OXFORDSHIRE COUNTY COUNCIL'S RESPONSE TO CONSULTATION ON THE FOLLOWING DEVELOPMENT PROPOSAL

Application no: 14/01888/F-3

Proposal: Erection of two local centre buildings - one to contain four apartments (3 x 2 bed and 1 x 1 bed) over one retail unit and a surgery and the other to contain four apartments (2 x 1 bed, 1 x 2 bed and 1 x 3 bed) over three retail units and a nursery

Transport

Title
**Sketch Scheme:
 Elevations and
 Typical Shopfront Section**

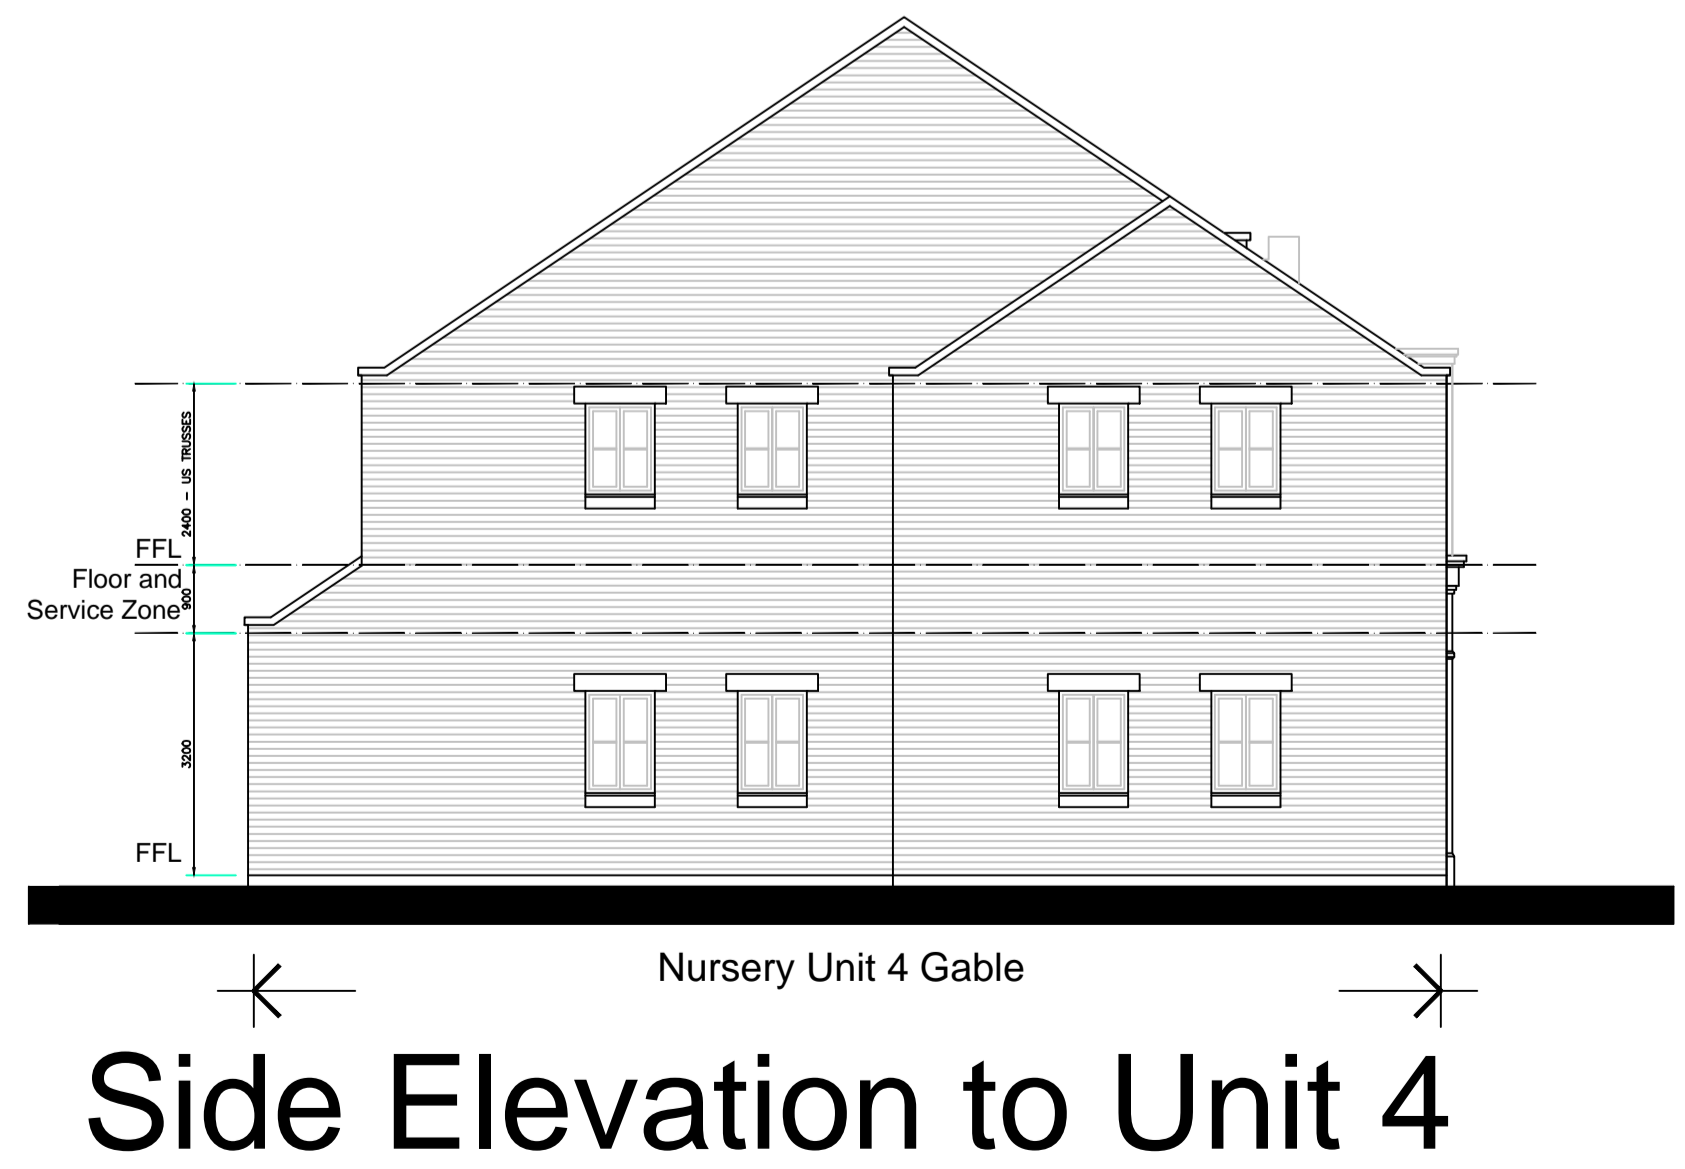
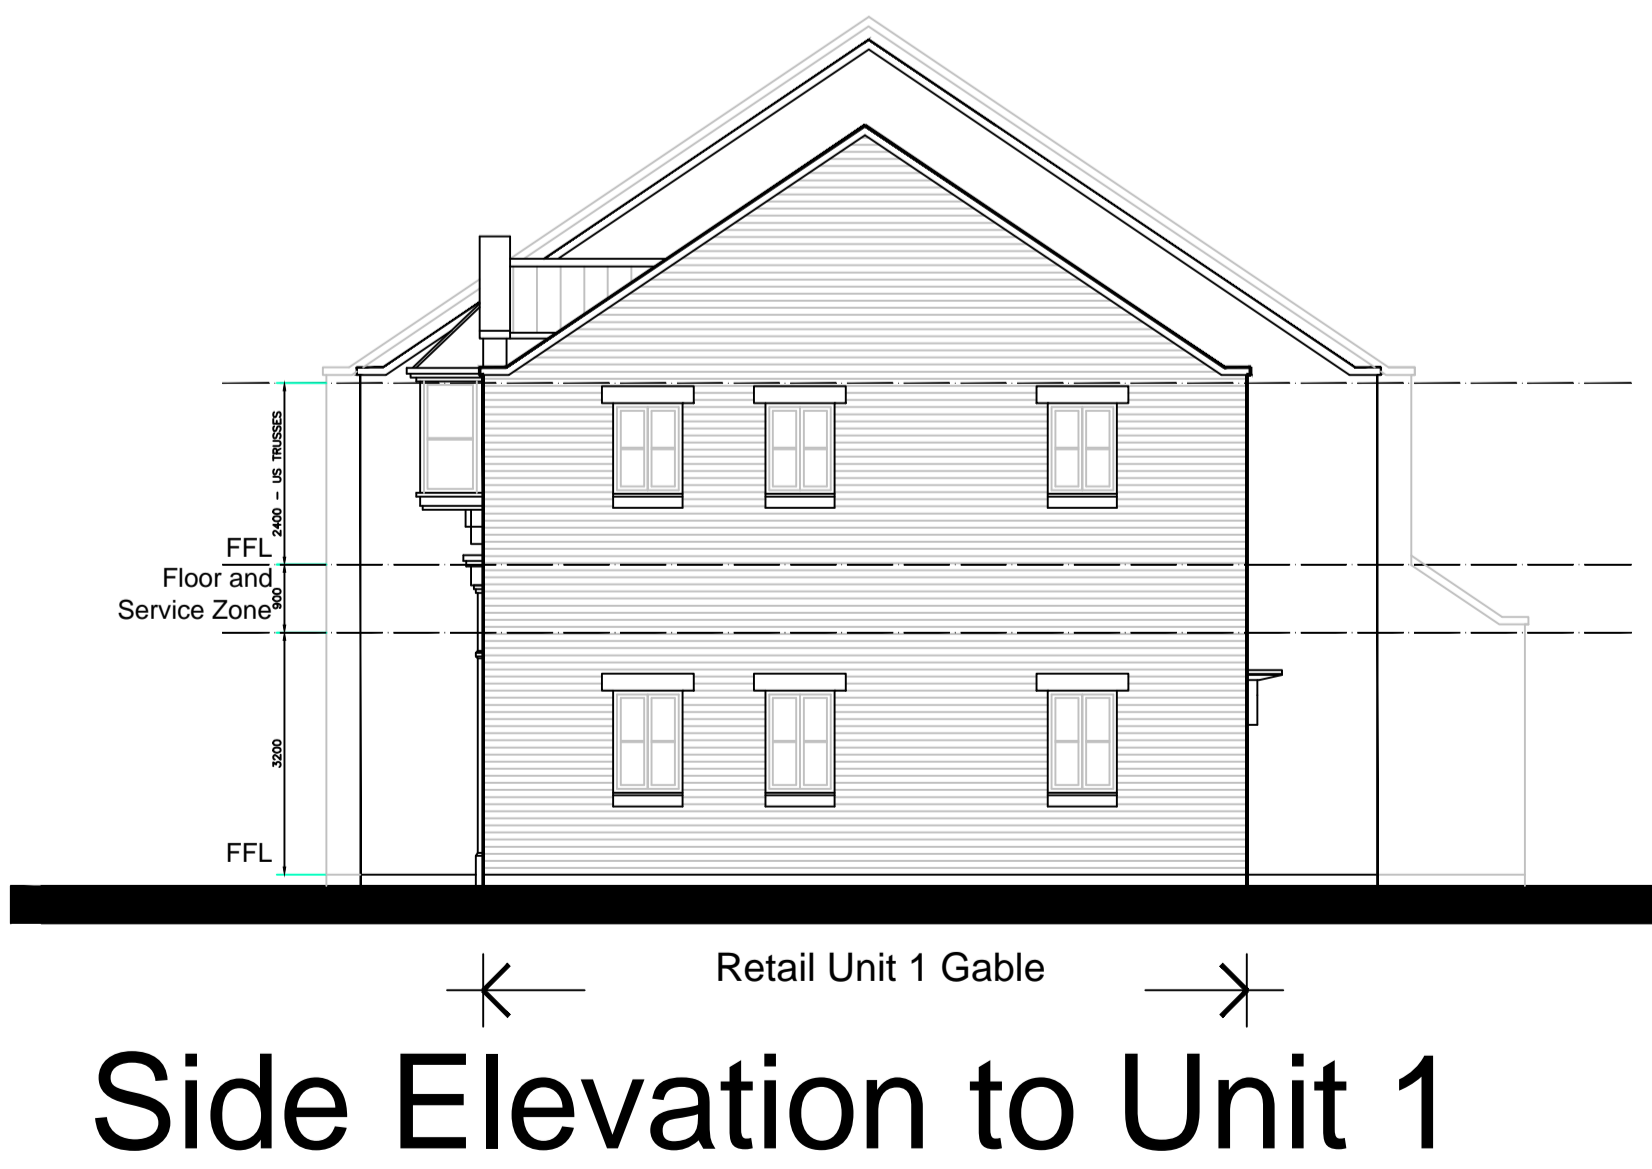
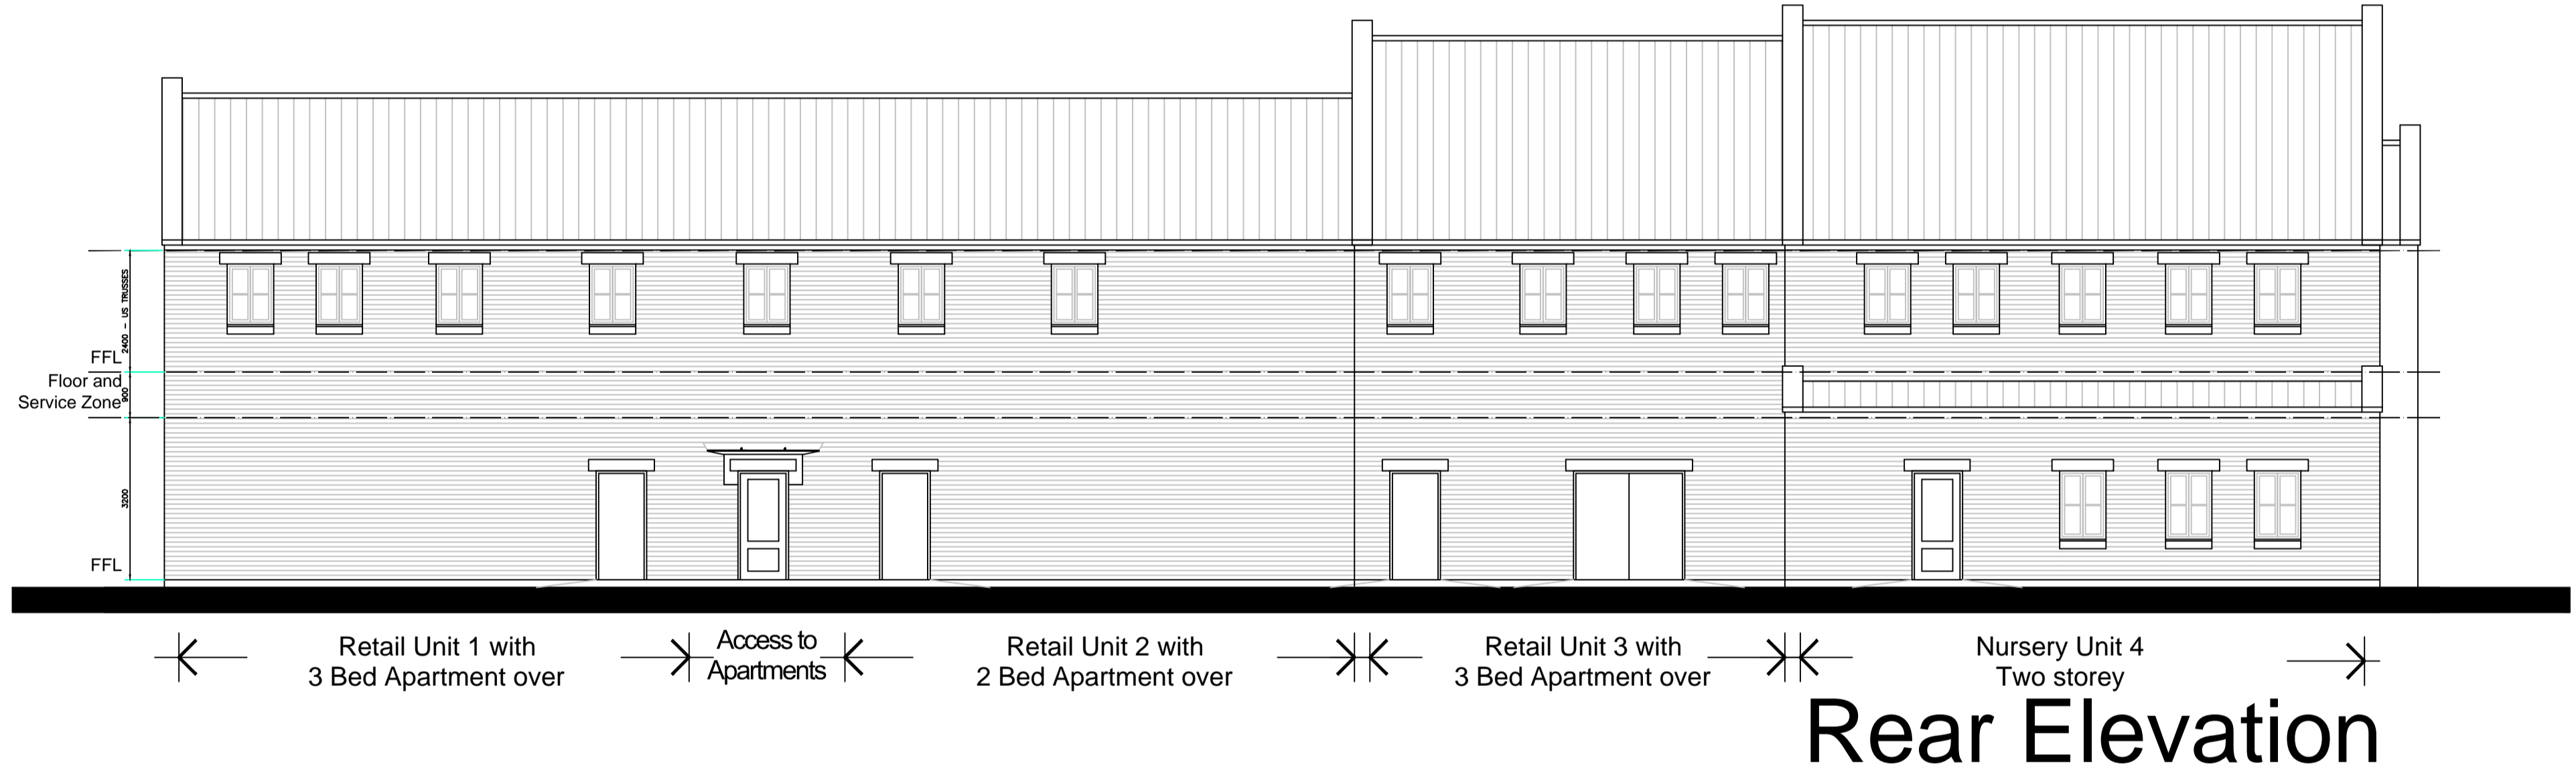
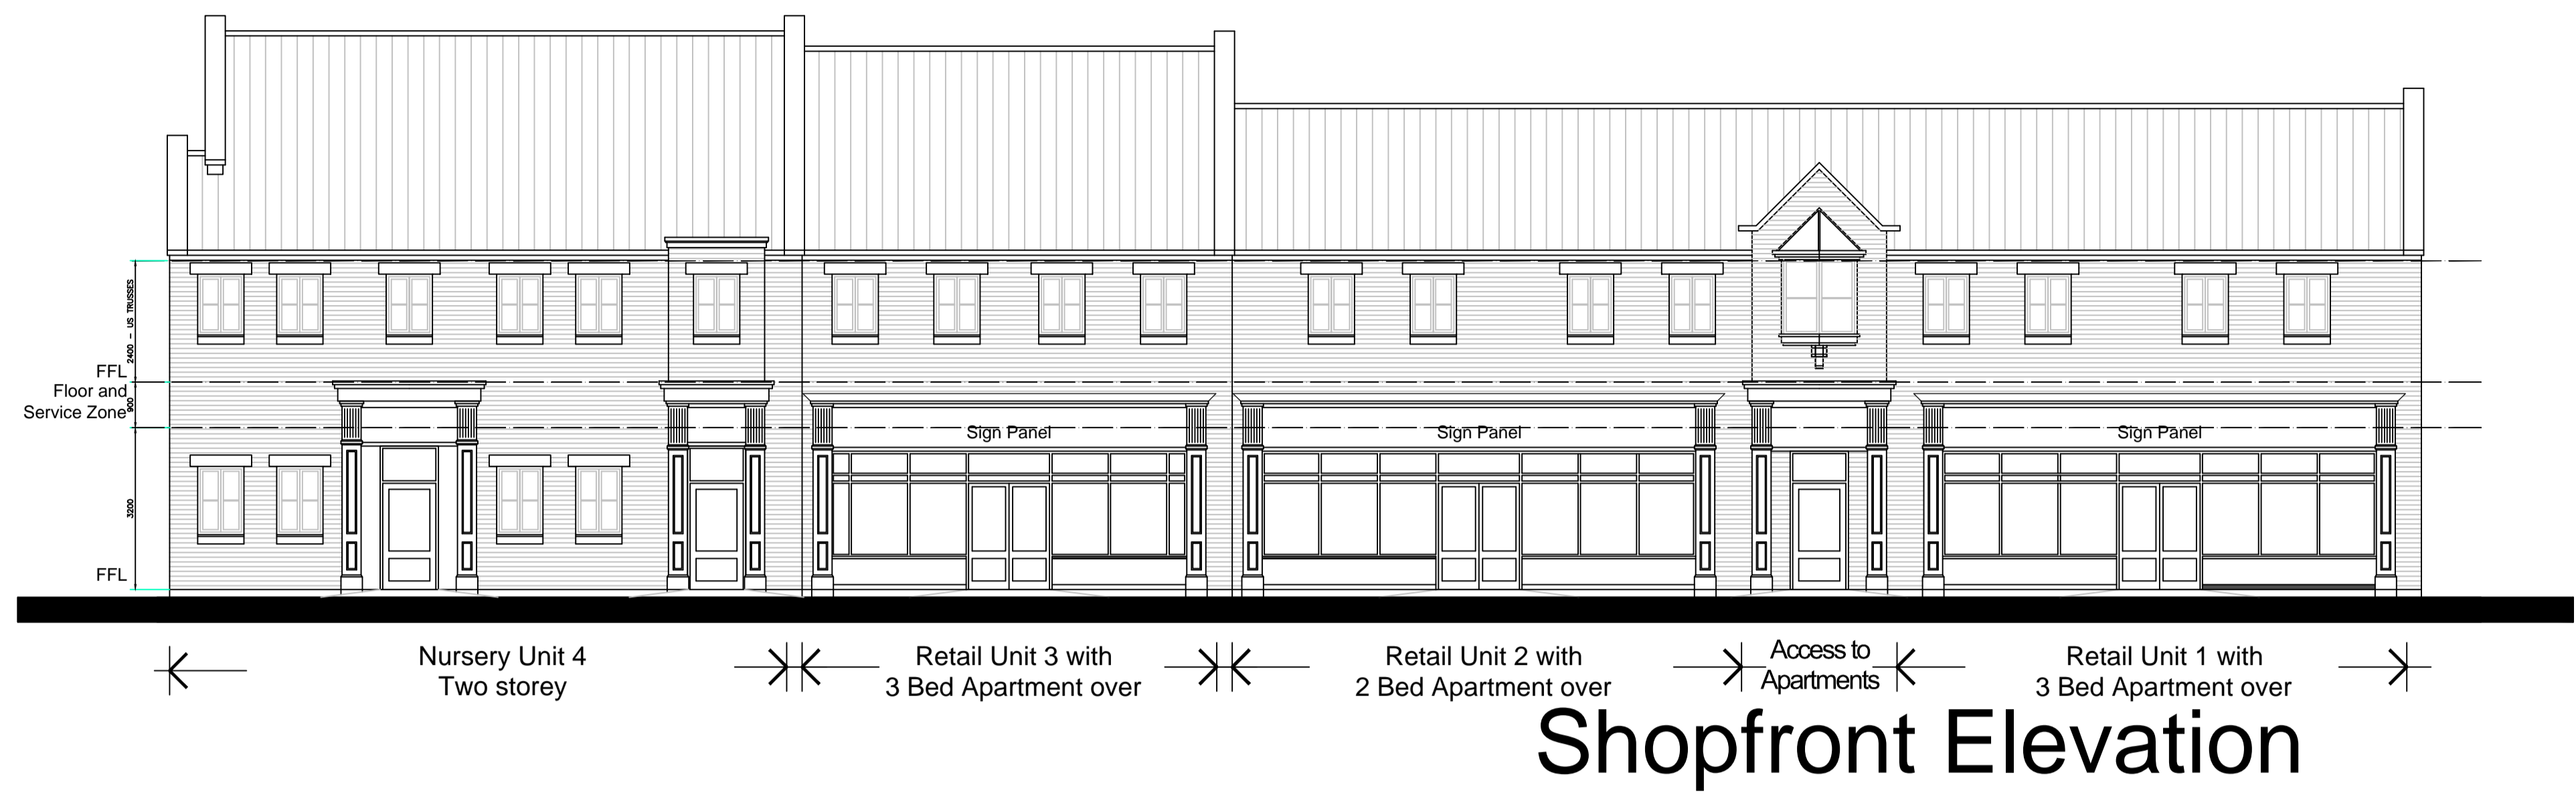
- Only four staff car parking spaces have been provided for the three retail units and nursery. Given the likely operational need for retail managers to have a car, and the high staffing levels in nurseries, this seems very low, which will lead to the likelihood of spaces being taken up in the public parking area all day by staff. Indiscriminate overspill parking
